**Review of Applicants Response to Submissions – Snack Brands
Warehouse and Distribution Facility (SSD 9429) at Nos. 585 – 649 Mamre
Road, Orchard Hills**

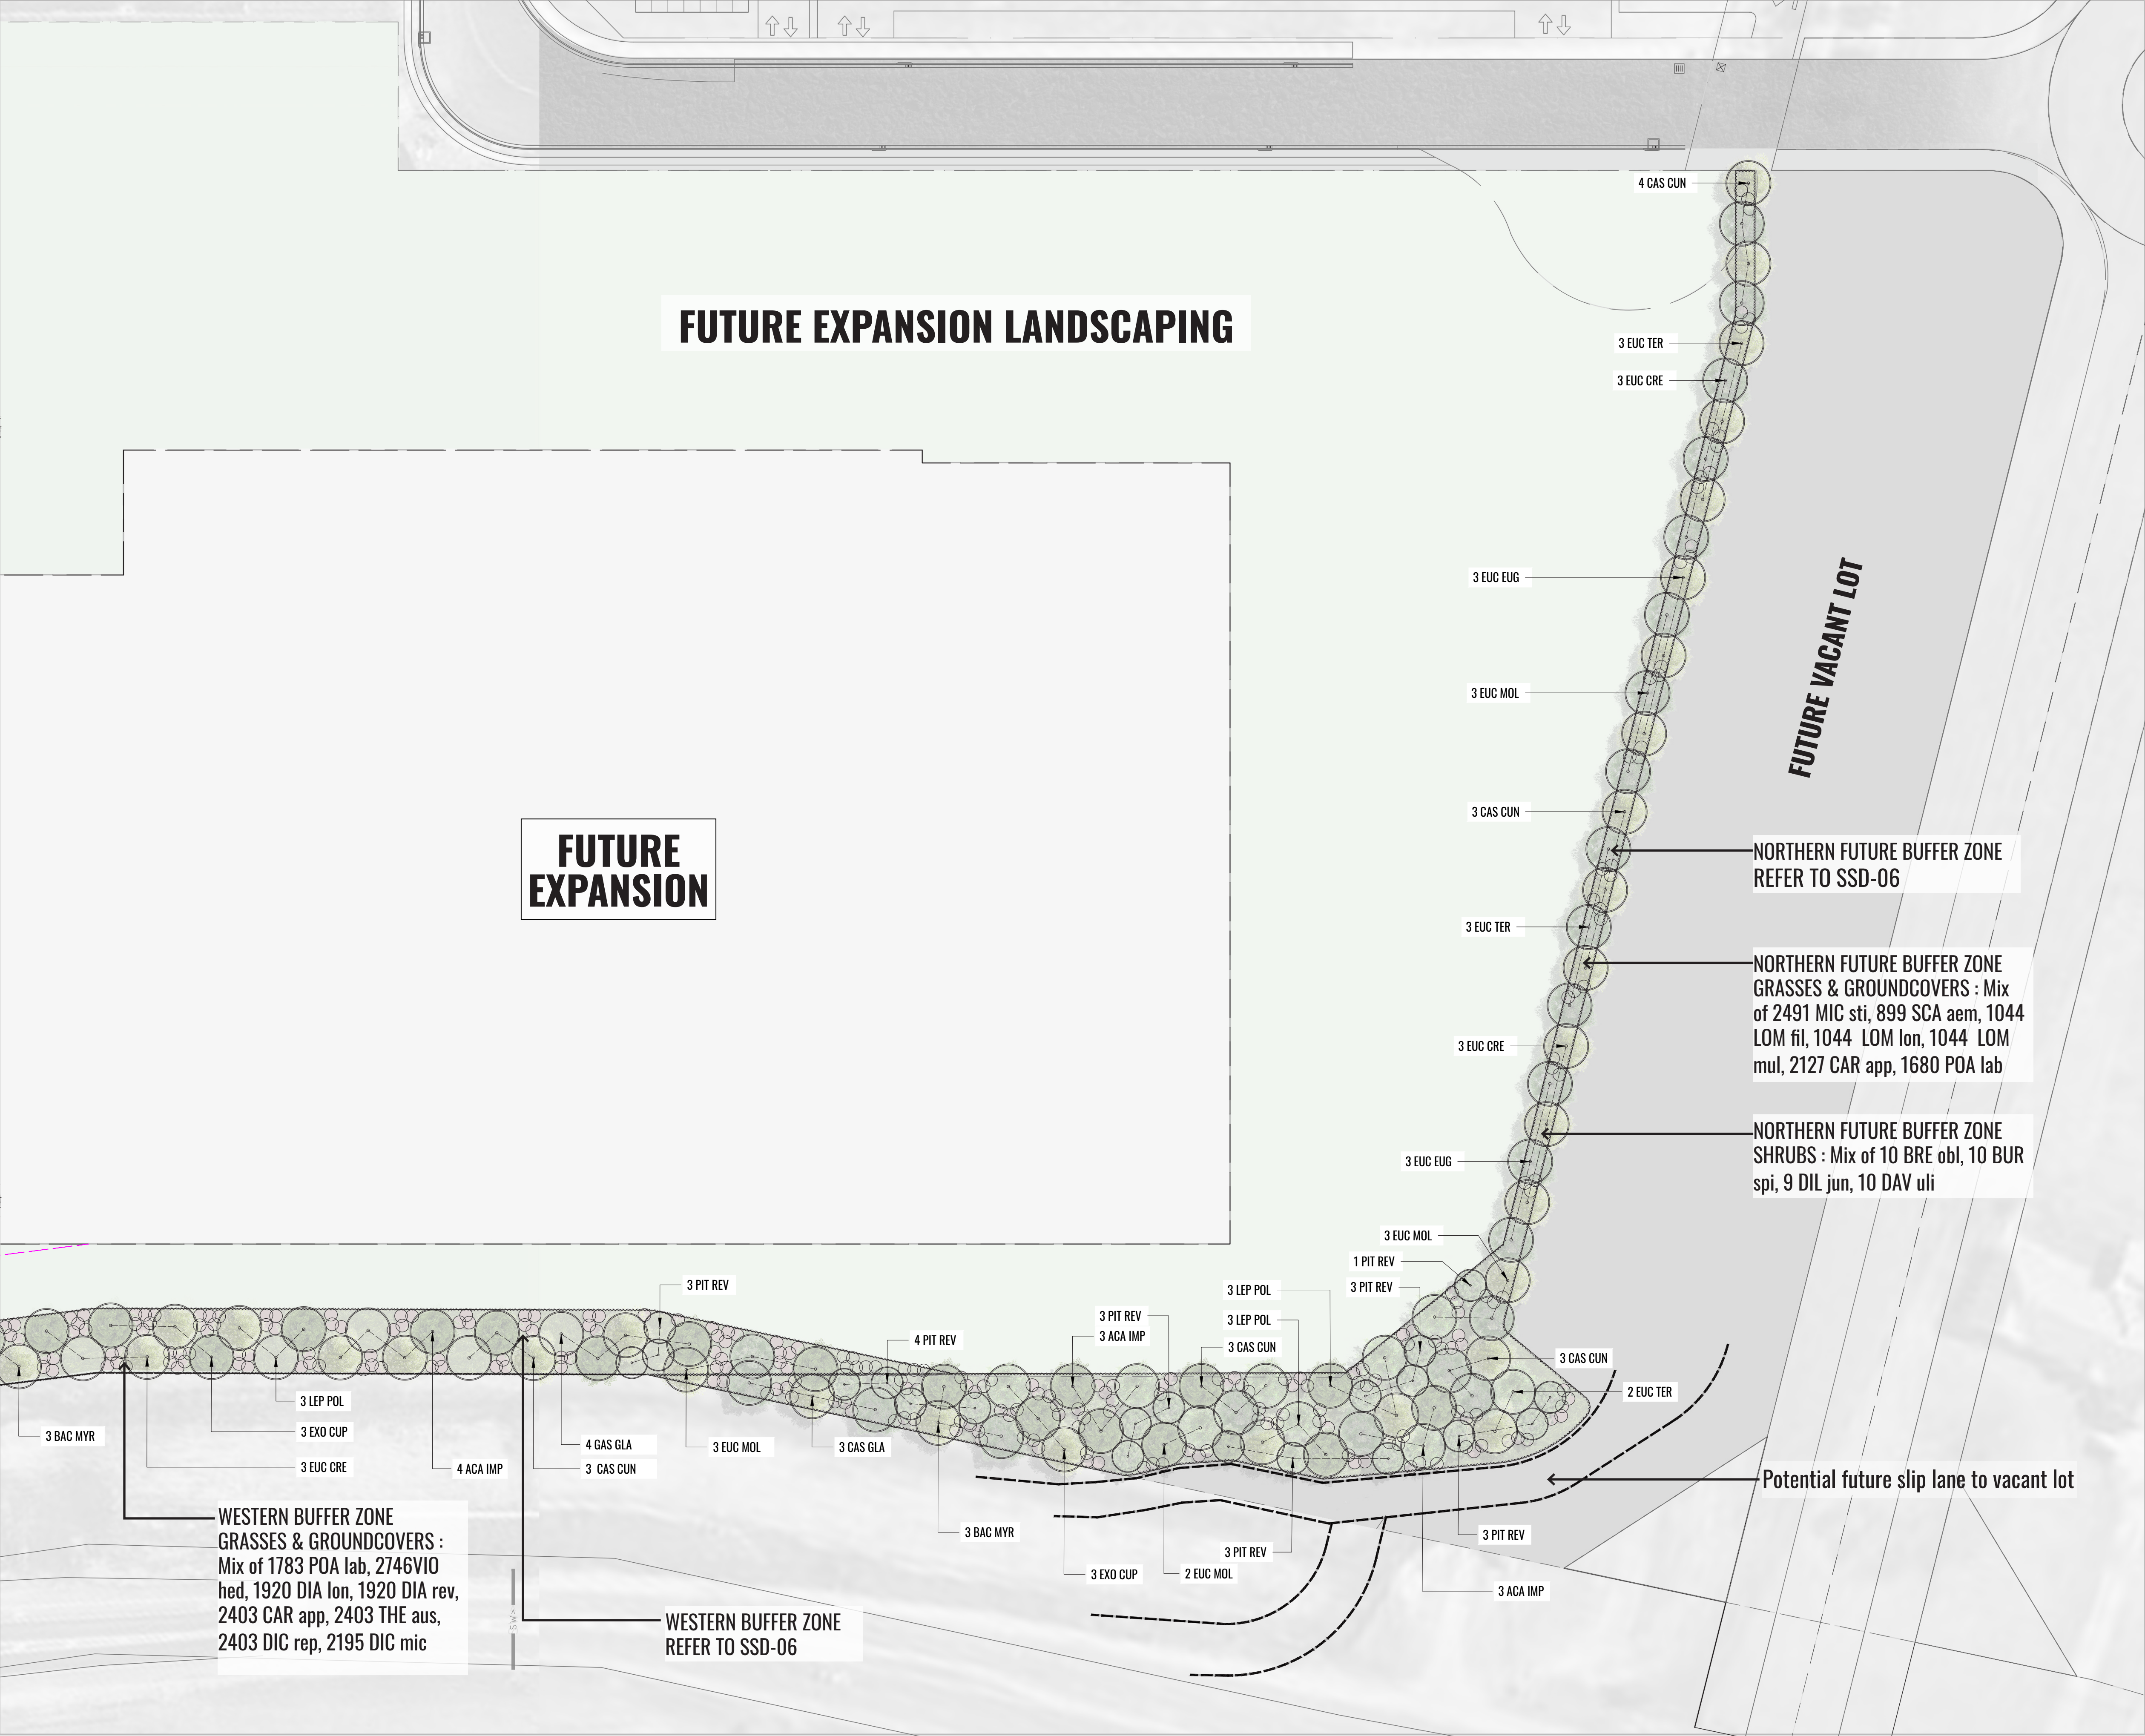
The application makes reference to pylon signage (including a notation on the landscape plan). Council's DCP provisions relating to pylon signage for a business park, industrial or commercial area limit pylon signage height to no greater than 7.0m.

Noting that the Mamre West Investigation Area DCP does not appear to provide dimensional controls for signage structures, any signage approved as part of this application should ensure compliance with Chapter C9 – Advertising and Signage within Penrith DCP 2014 being 7.0m maximum height and graphic / advertising detail in accordance with Clause 9.1 – General Requirements of the above DCP. It is noted that this could be addressed through conditions of consent if the application was supported.
